**RE: Clint Short Plat (SP-08-00054)**

The Kittitas County Community Development Services Department has determined that the Clint Short Plat (SP-08-00054) is a complete application and hereby grants *conditional preliminary approval* subject to the following conditions:

CHKD. BY	JMB	SCALE	VARIES	SHEET	2 OF 2
DWN. BY	KJW	DATE	11/24/08	JOB NO.	00731.031

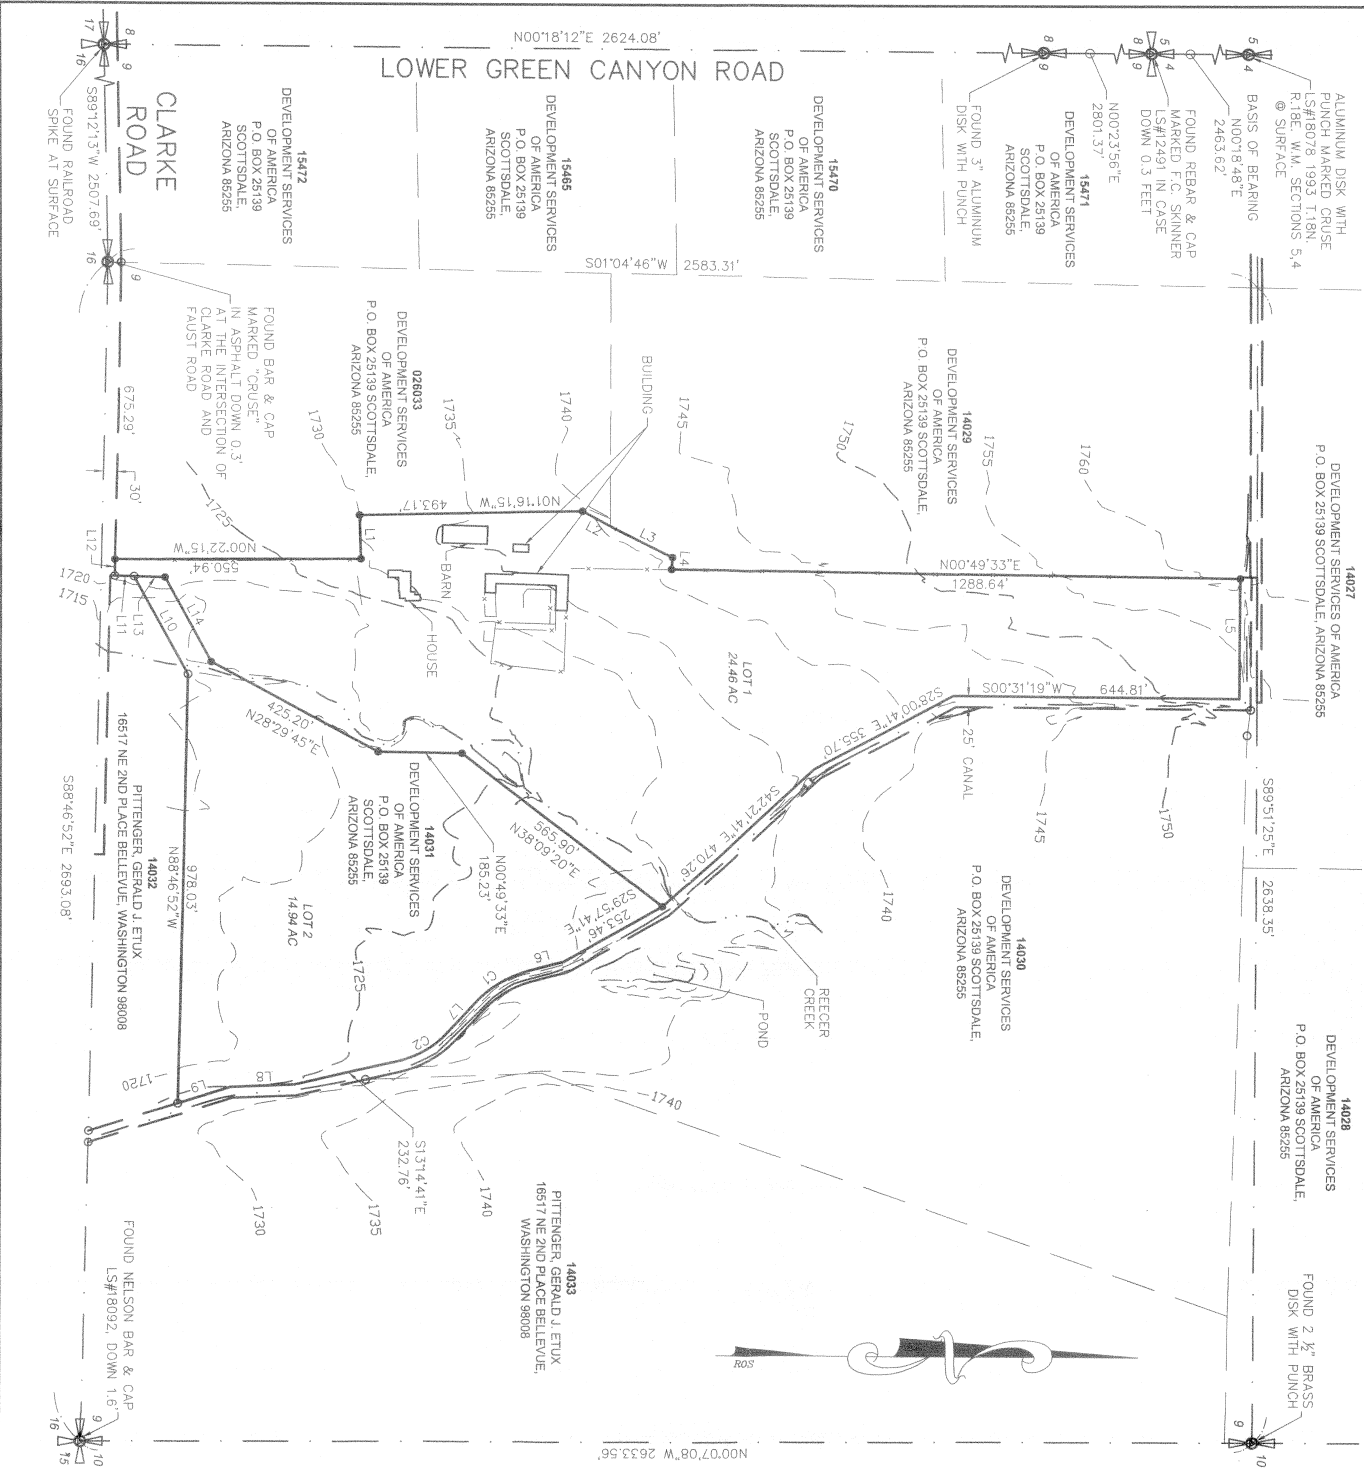
1. Both sheets of the final mylars shall reflect short plat number SP-08-00054 and an accurate legal description shall be shown on the face of the final plat.

10. Portions of both proposed parcels in the Clint Short Plat are shown on FEMA Flood Insurance Rate Map Panel 5300950437B as being within the 100 year Floodplain. As per KCC 17A.05.015, all preliminary plats must clearly delineate the one-hundred-year floodplain boundary, according to the FEMA Flood Insurance Rate Map. Any future development occurring within the designated Floodplain shall be subject to the regulations established in KCC Chapter 17A.05 (Ord. 93-18 by reference).

11. Lot 1 of the Clint Short Plat has PEMC and PUBHx wetlands across the west end of the property. The final mylars shall reflect the location of these wetlands and a statement on the plat shall read as follows: "Future development of lots may require a study by a certified wetland biologist to determine wetland classification and for buffer requirements pursuant to KCC Critical Areas Code."
